The Parish Councils of Assington, Bures St Mary, Leavenheath, Little Cornard, Polstead & Stoke by Nayland

Further written comments on Cable Sealing End Compounds following Bramford-Twinstead (EN020002) Issue Specific Hearing 4

DEDHAM VALE EAST SEALING END COMPOUND:
 PLAN VIEW
 SCALE 1:200

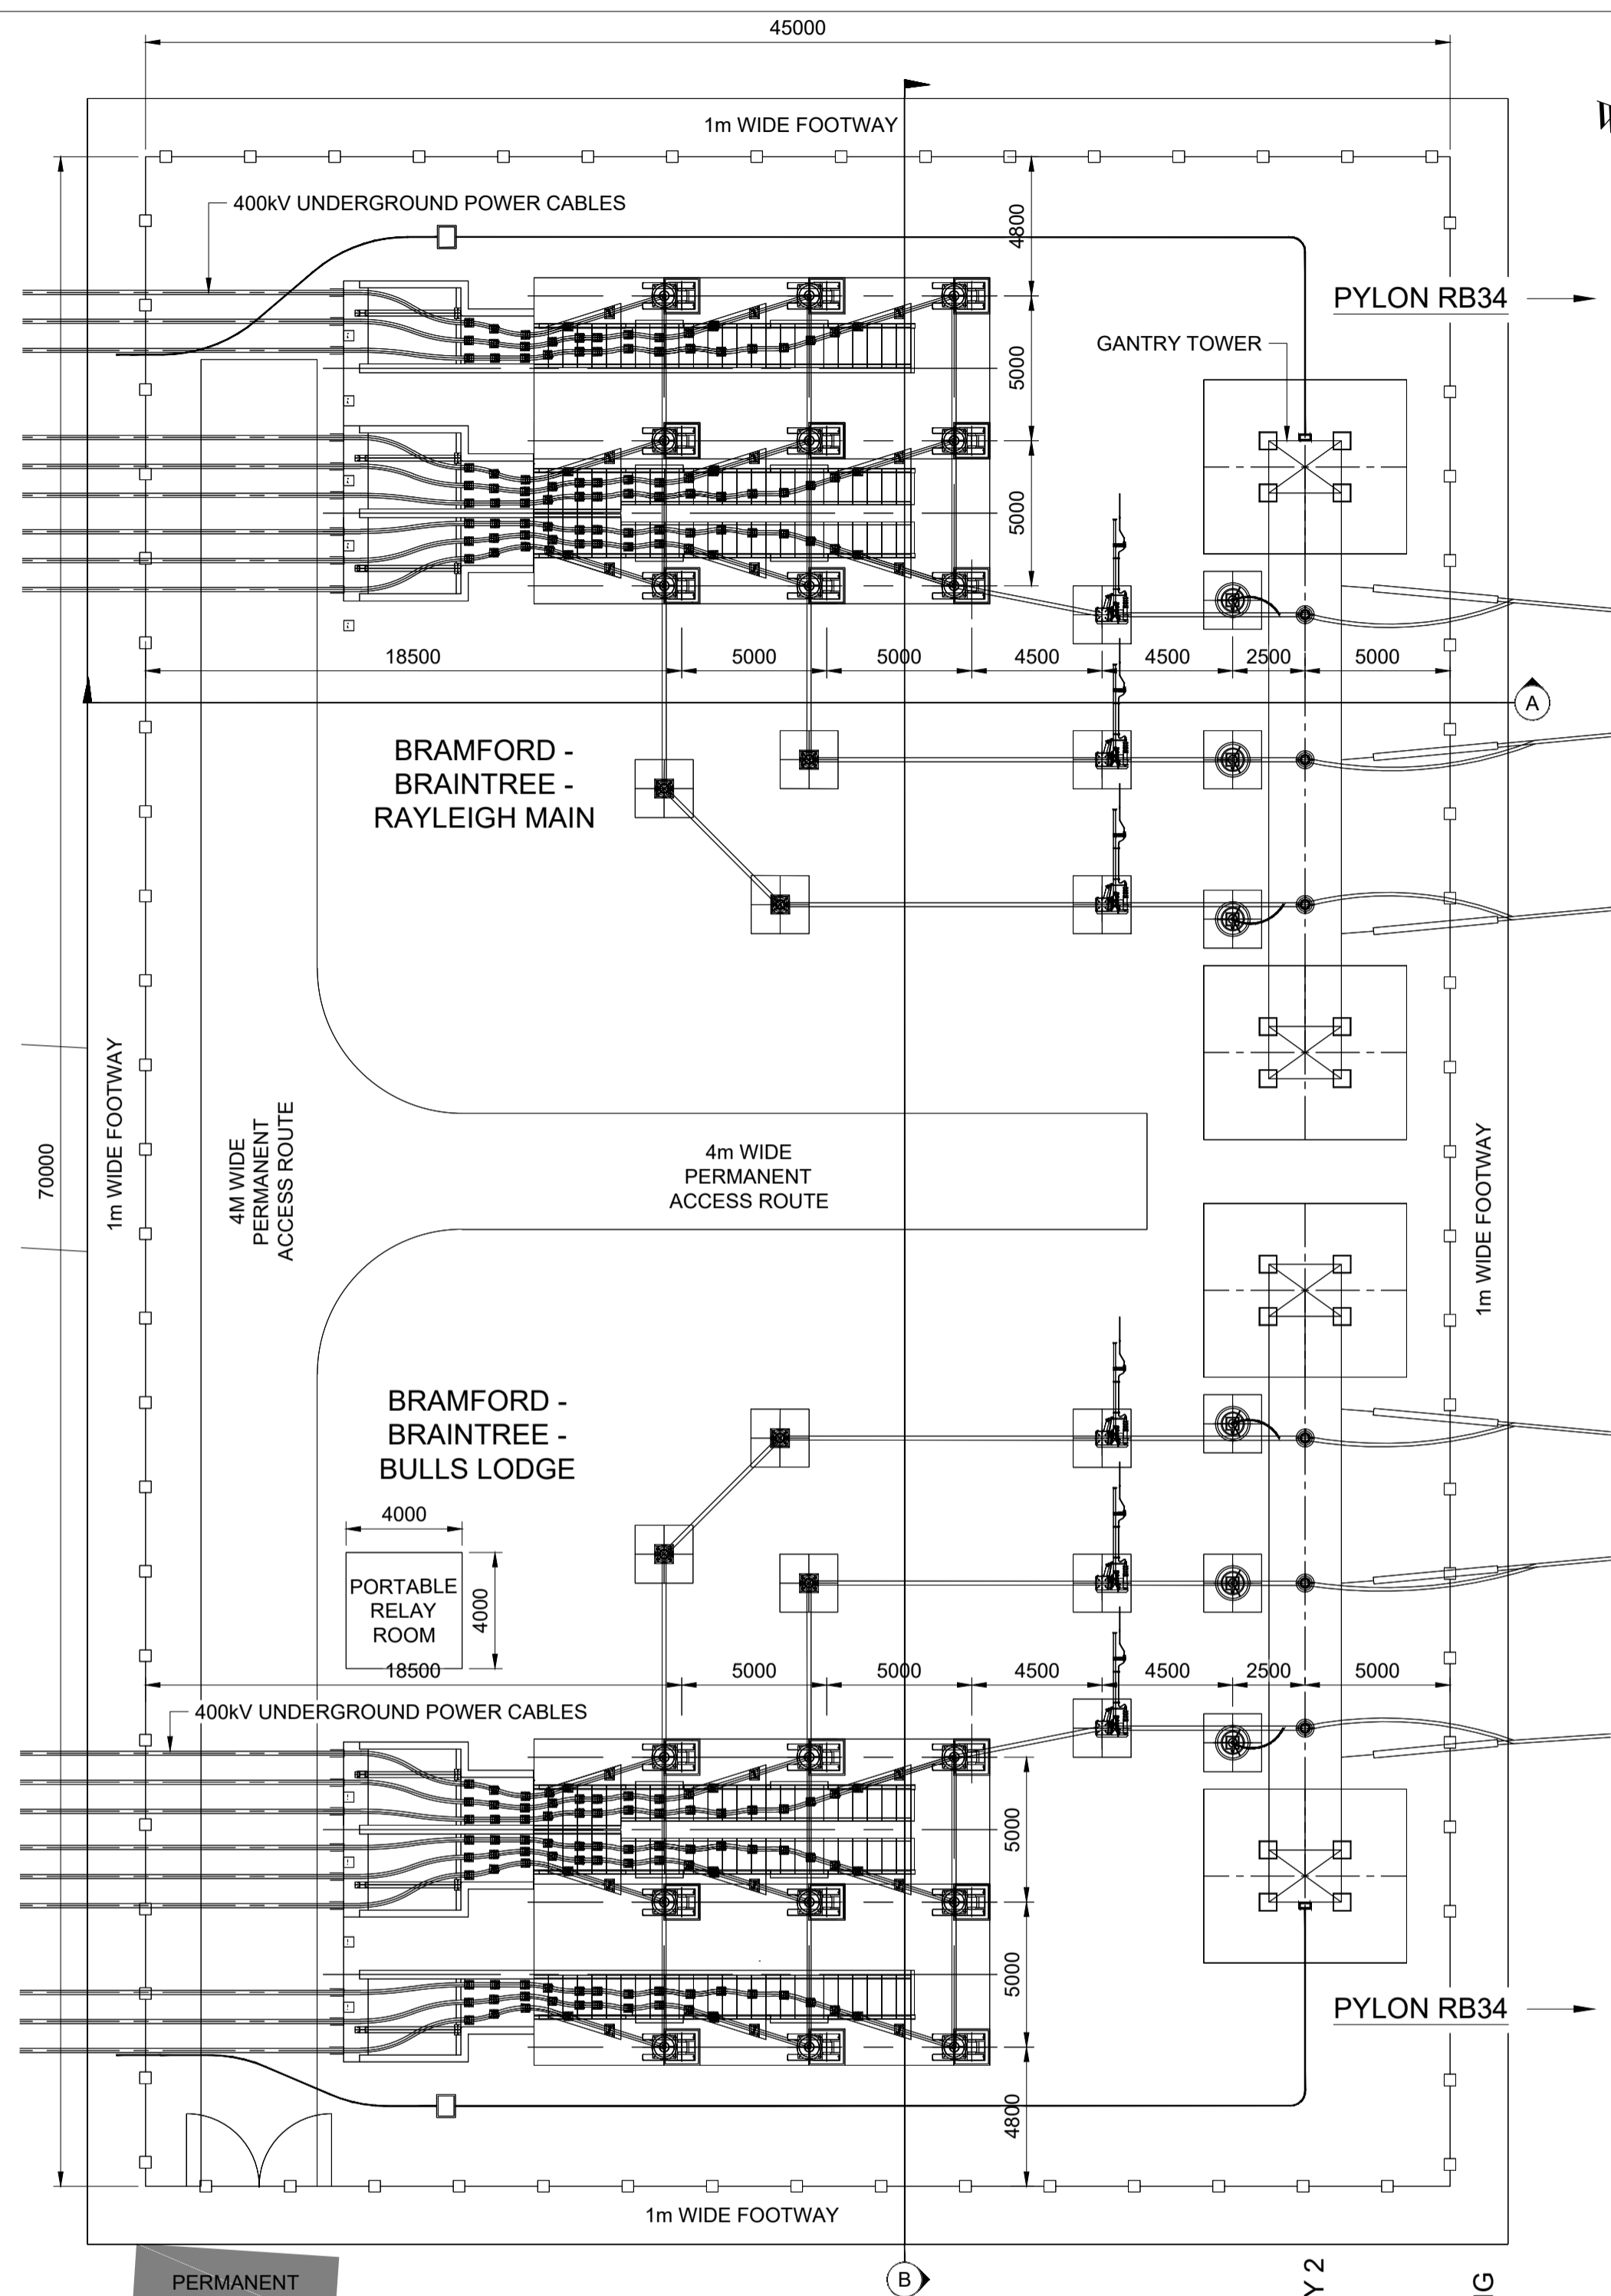
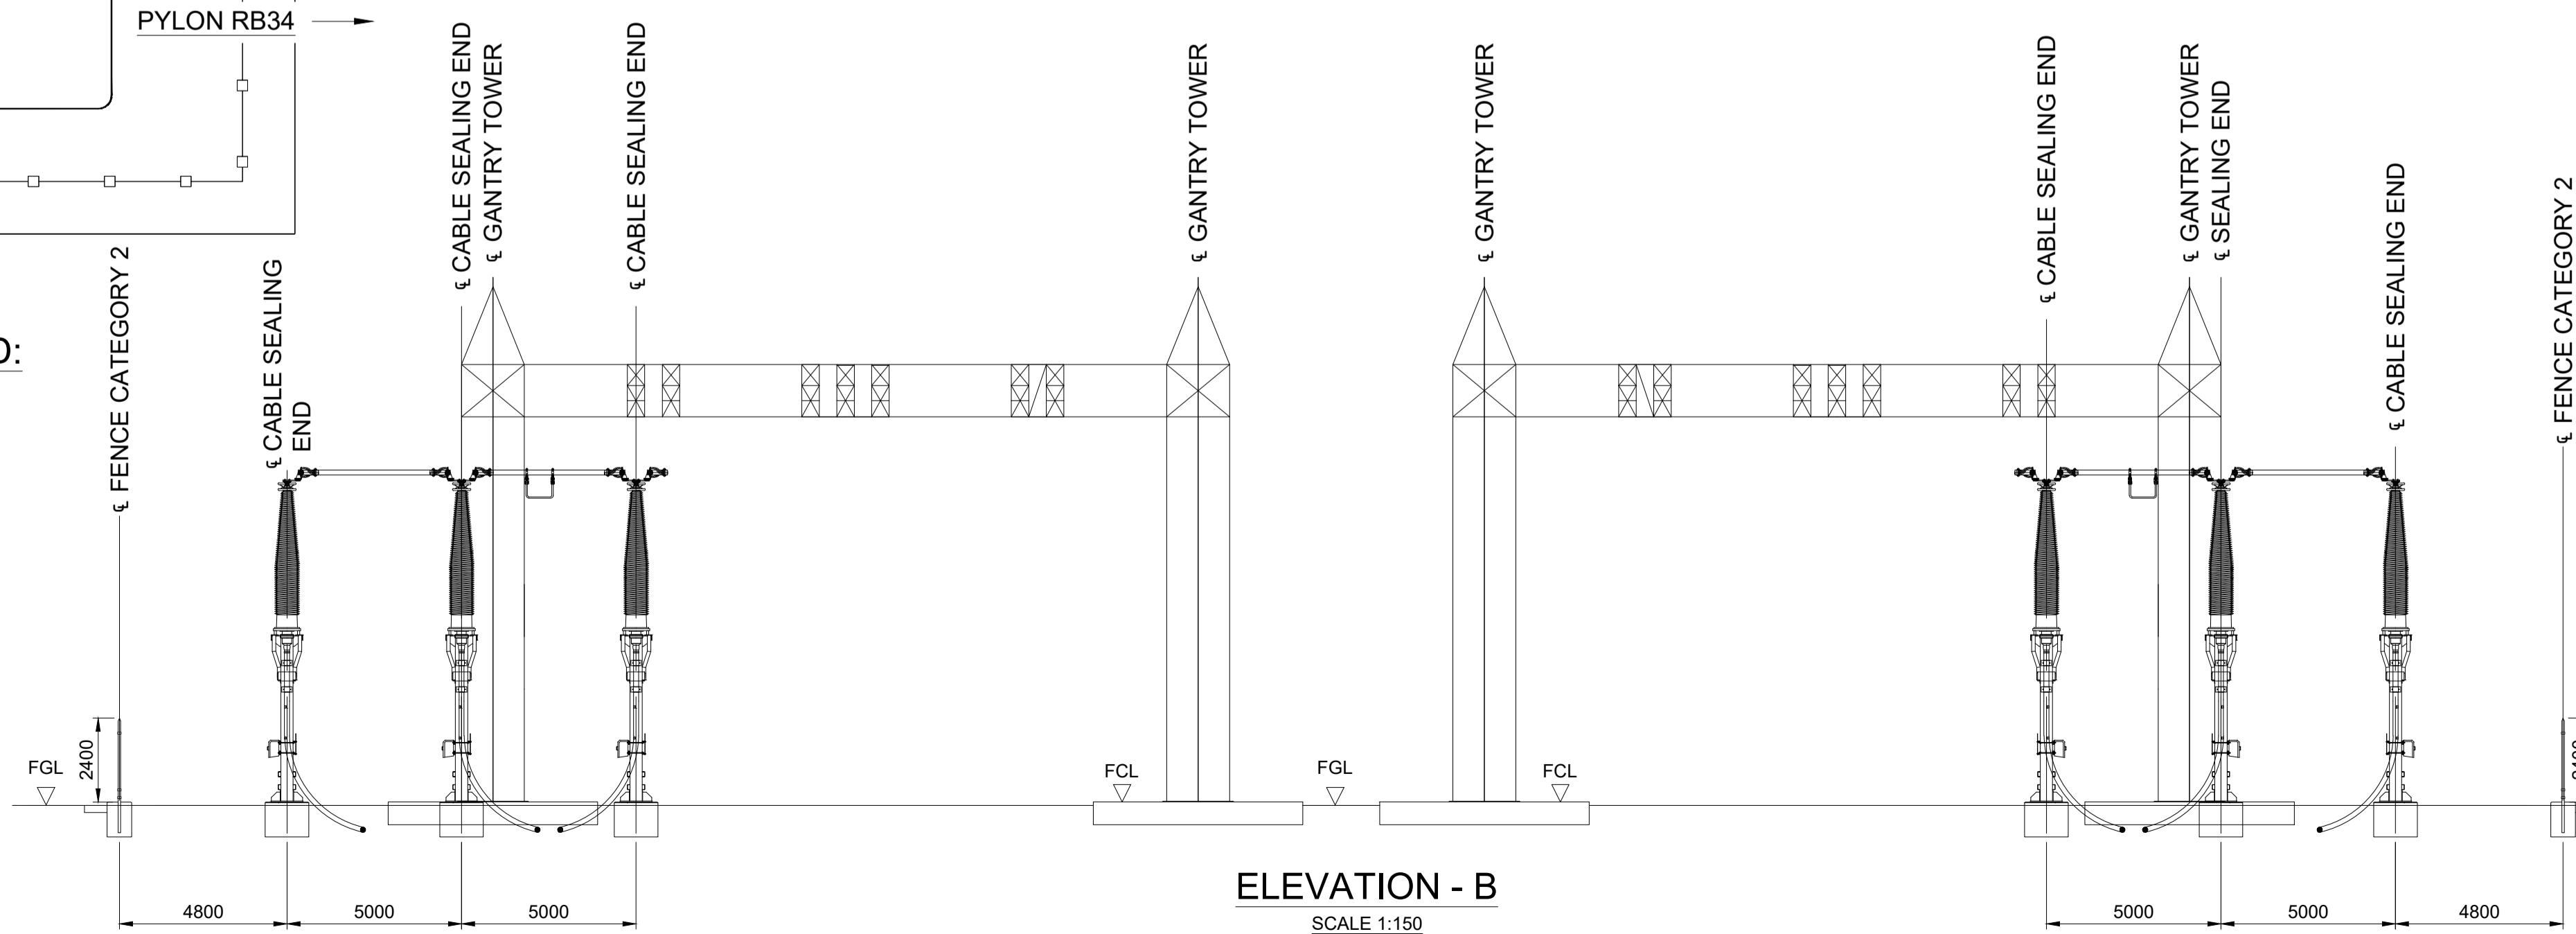
- 3.1 Two further benefits of relocating the CSEC from the Millfield Woods site to Layham Quarry have been identified.
- 3.2 Releasing the Millfield Woods site would allow some 5.6Ha (by our estimation) of land to be returned to productive agricultural use post-construction.
- 3.3 Furthermore, consequential to the additional section of undergrounding, the removal of pylon PCB42 and the cancellation of new pylon RB33 would dramatically improve the setting of Pope's Green Farm, a Grade
